### RE: Wenger Short Plat (SP-07-00007)

The Kittitas County Community Development Services Department has determined that the Wenger Short Plat (SP-07-00007) is a complete application and hereby grants *conditional preliminary approval* subject to the following conditions:

KITTITAS COUNTY SHORT PLAT NO. 07-07
PORTION OF THE NE 1/4, SEC.29 T.20N., R.14E., W.M.
KITTITAS COUNTY, WASHINGTON

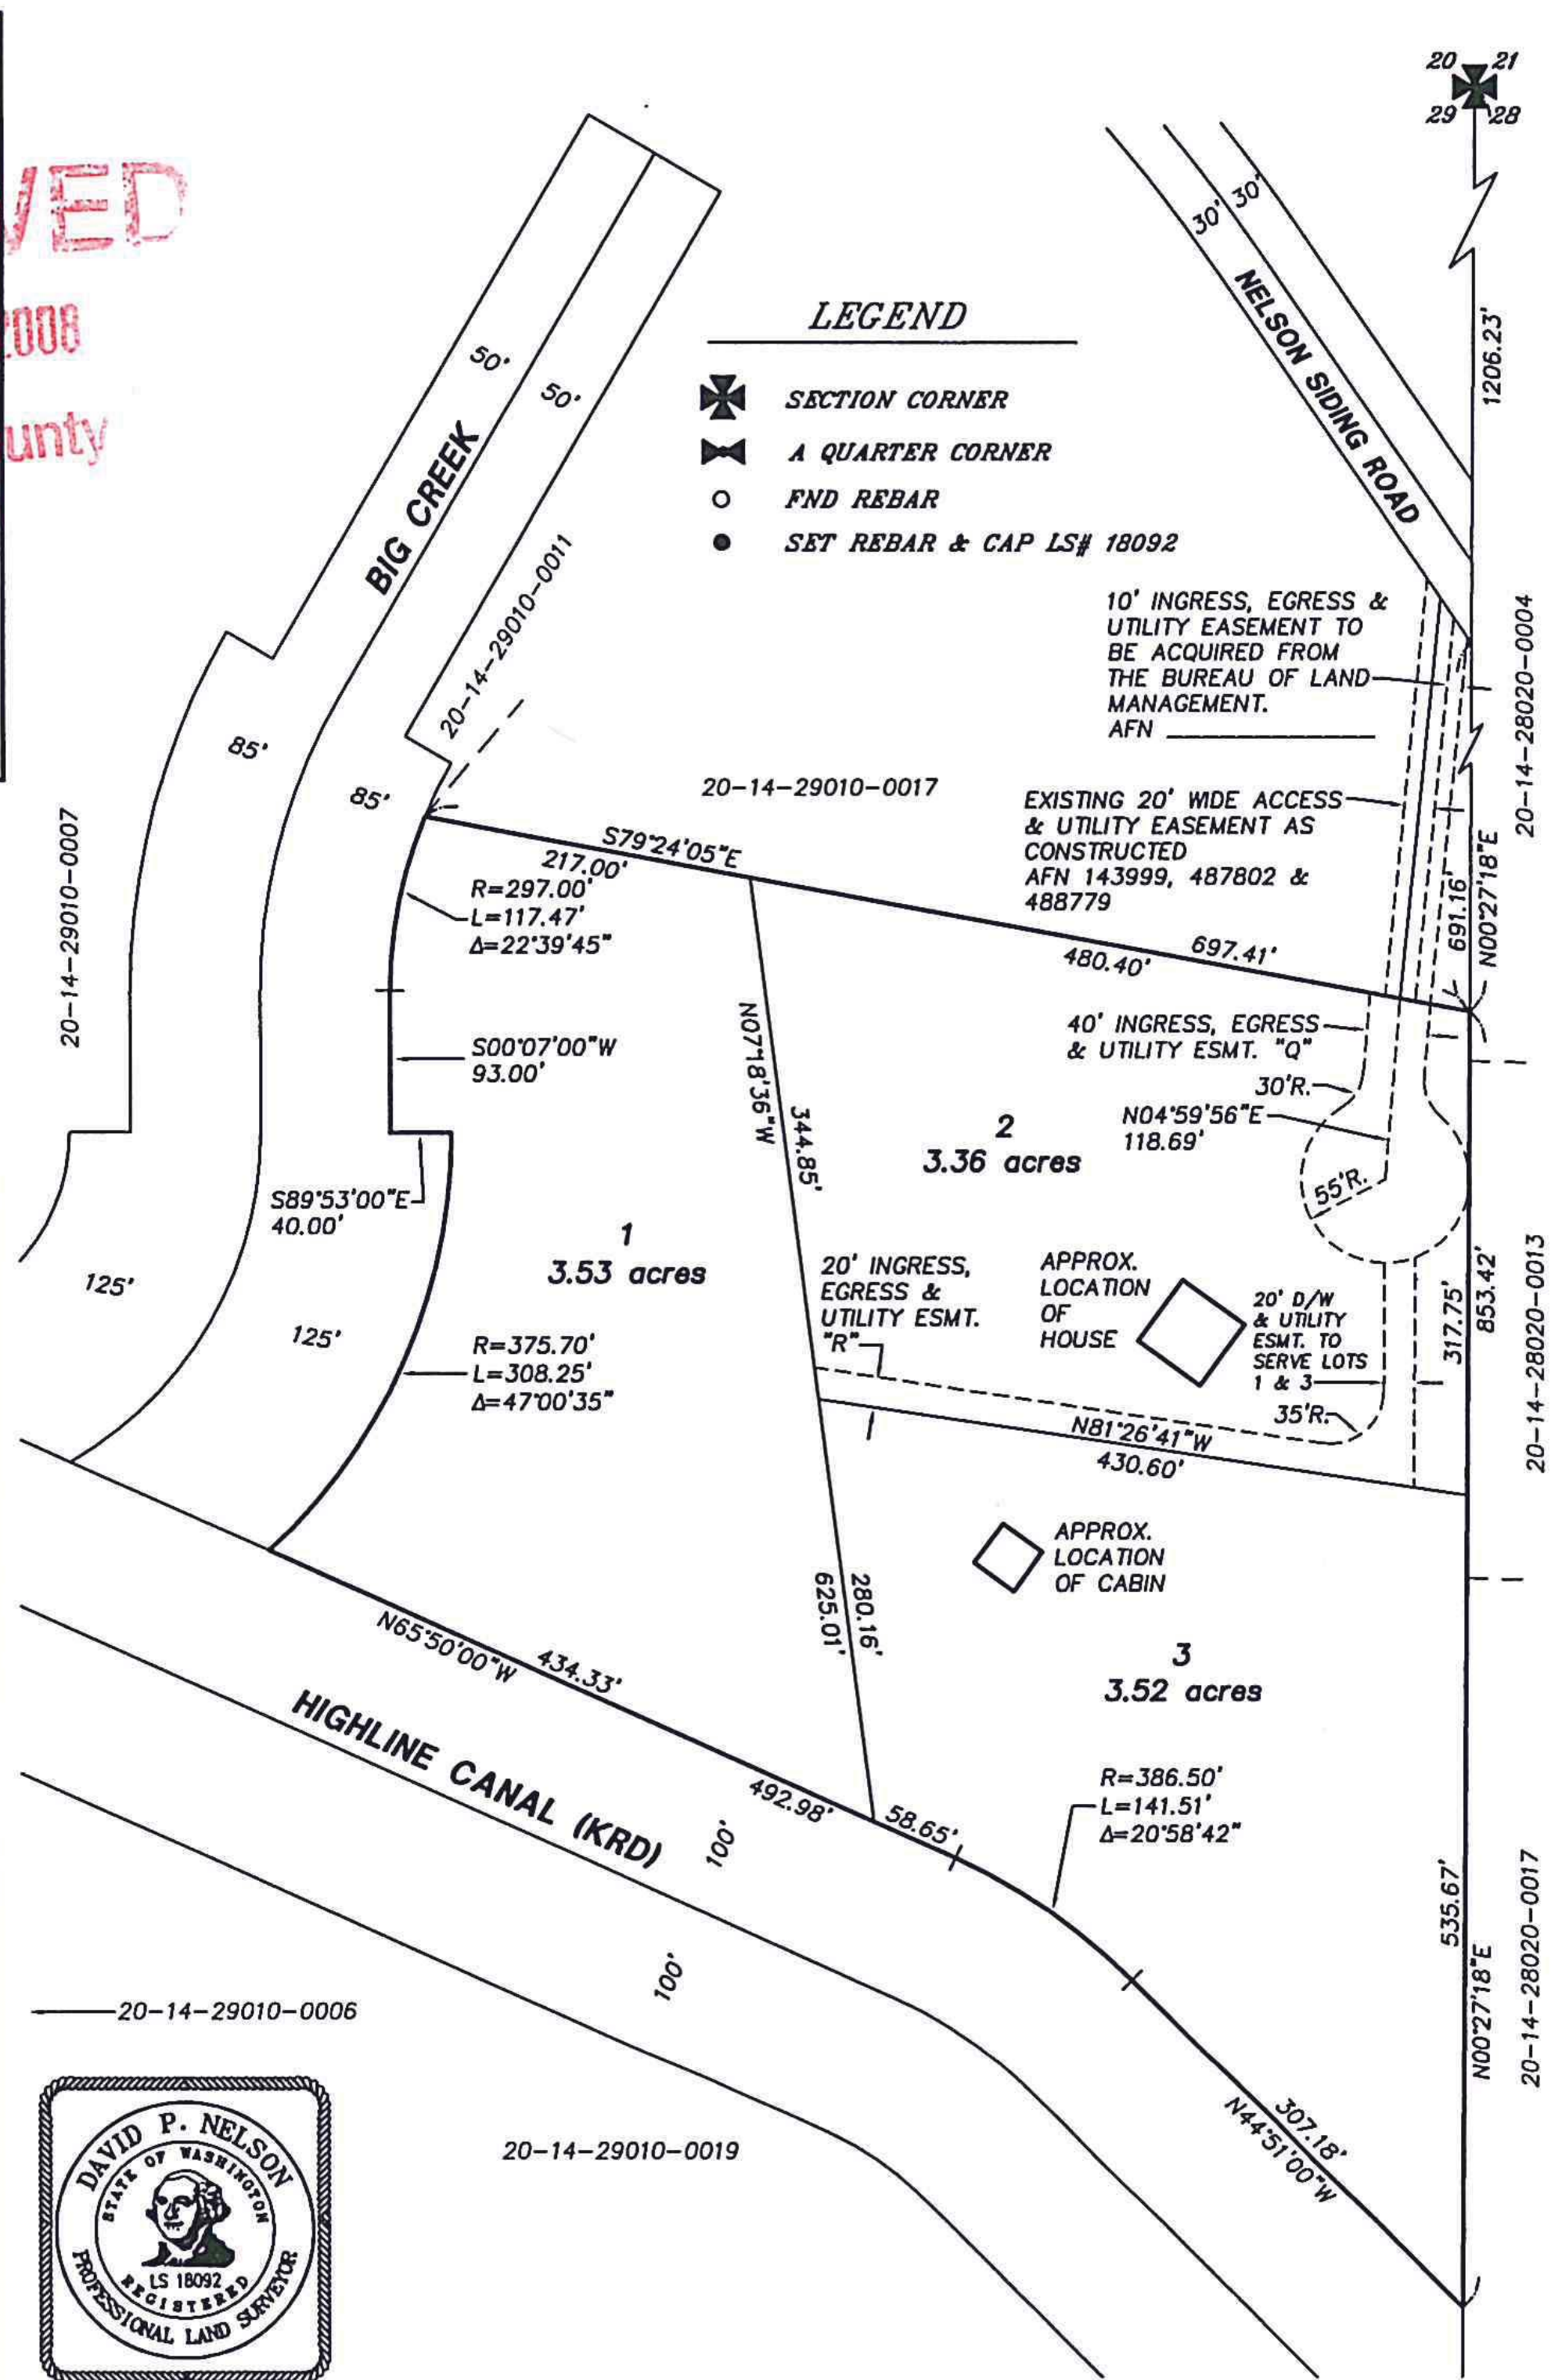
- d) **Final Plat:** The following items must be shown on the final plat:
  - i) 100-year floodplain
  - ii) Shoreline jurisdiction
  - iii) Big Creek
  - iv) KRD Lateral boundaries

- v) Easement and driveway serving parcel 616536
- e) **Floodplain:** A building site must be designated outside of the 100-year floodplain. If any construction of residential or non-residential buildings takes place within the 100-year floodplain, Base Flood Elevations must be determined for the entire subdivision.
